Application for removal or variation of a condition following grant of planning permission. Town and Country Planning Act 1990.
Planning (Listed Buildings and Conservation Areas) Act 1990

Number	<input type="text" value="76"/>
Suffix	<input type="text"/>
Property name	<input type="text"/>
Address line 1	<input type="text" value="Blackshots Lane"/>
Address line 2	<input type="text"/>
Address line 3	<input type="text"/>
Town/city	<input type="text" value="Grays"/>
Postcode	<input type="text" value="RM16 2JU"/>
Description of site location must be completed if postcode is not known:	
Easting (x)	<input type="text" value="562568"/>
Northing (y)	<input type="text" value="179729"/>
Description	<input type="text"/>

Please state the condition number(s) to which this application relates

Contract 76 Blackshots Lane, Grays, RM16 2JU
Description AS BUILT ELEVATIONS SHOWING CLADDING INSTALLED

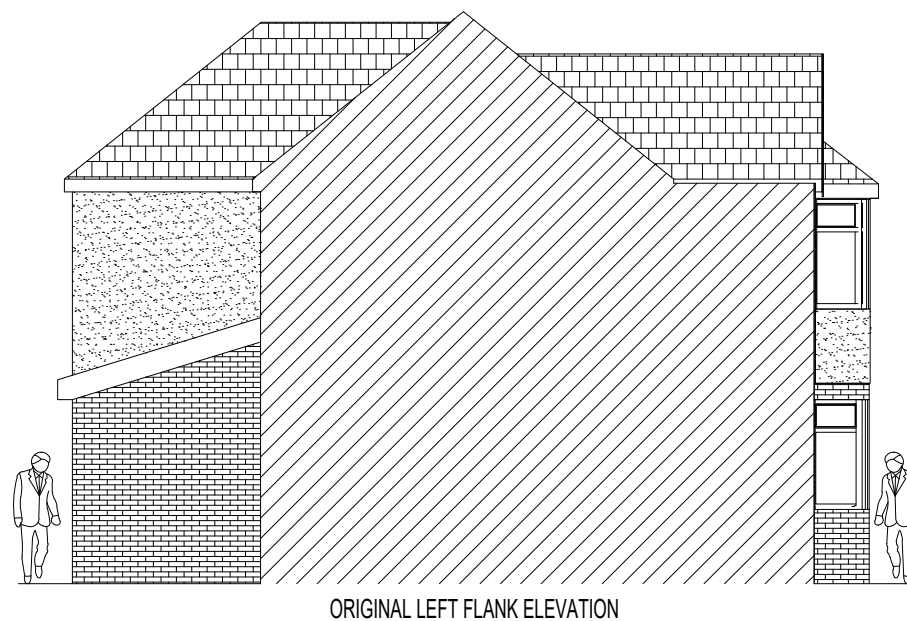
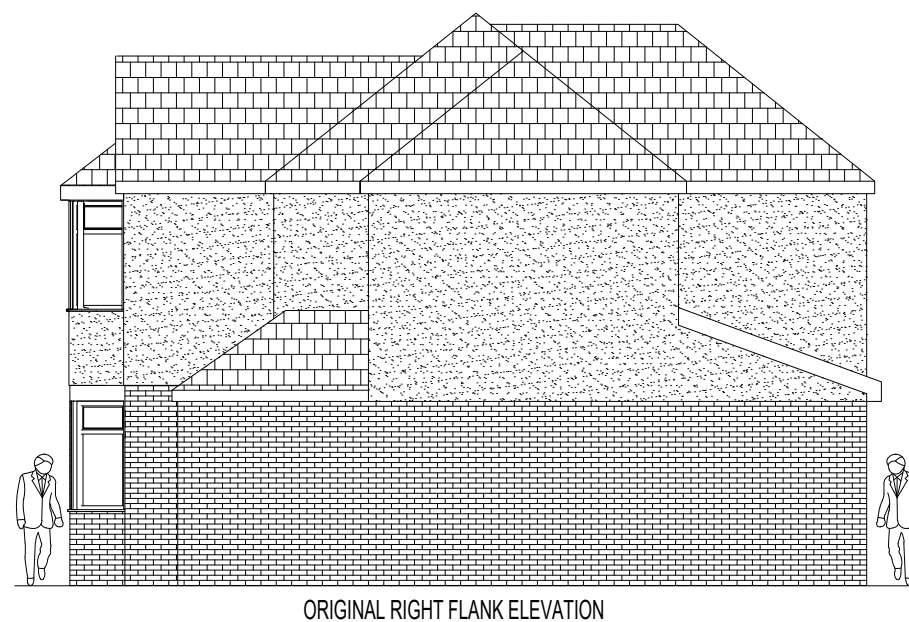
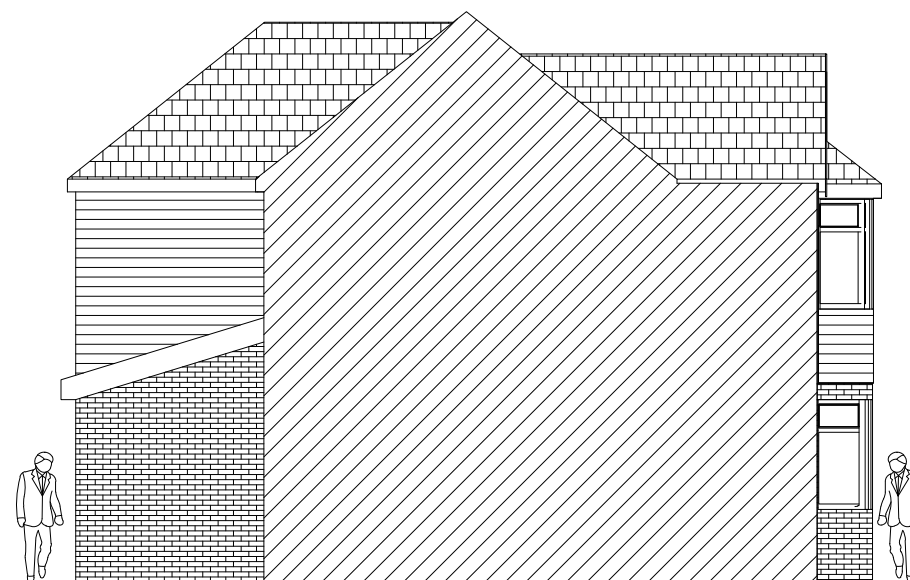
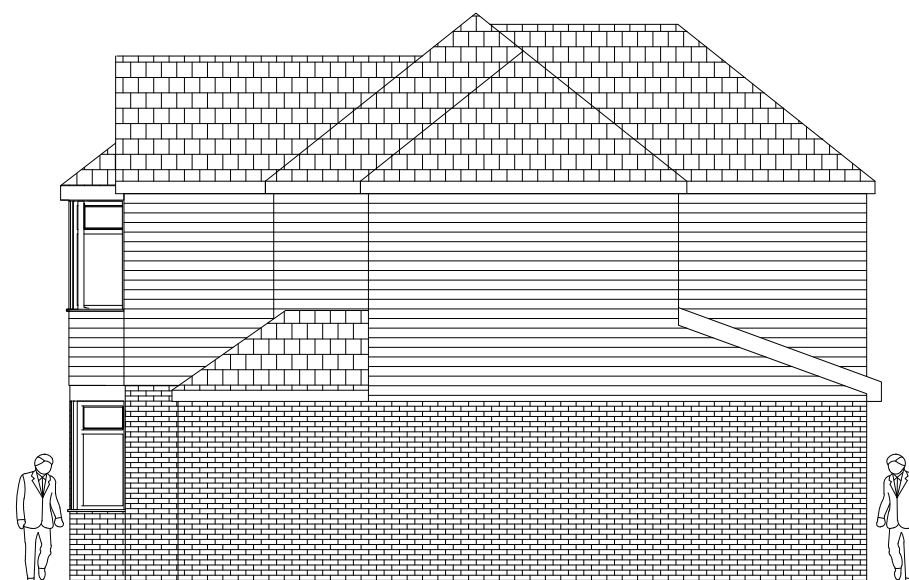
The owners had cladding installed due to the visuals of the old and shabby look of the original pebble dash. The original walls were in need of major repairs which is very awkward to do as any new repairs never match existing pebble dash due to weathering. So new cladding was installed to cover up the old pebble dash.

New external finishes to the top half of the property is acceptable as the whole house has been upgraded to match on all walls.
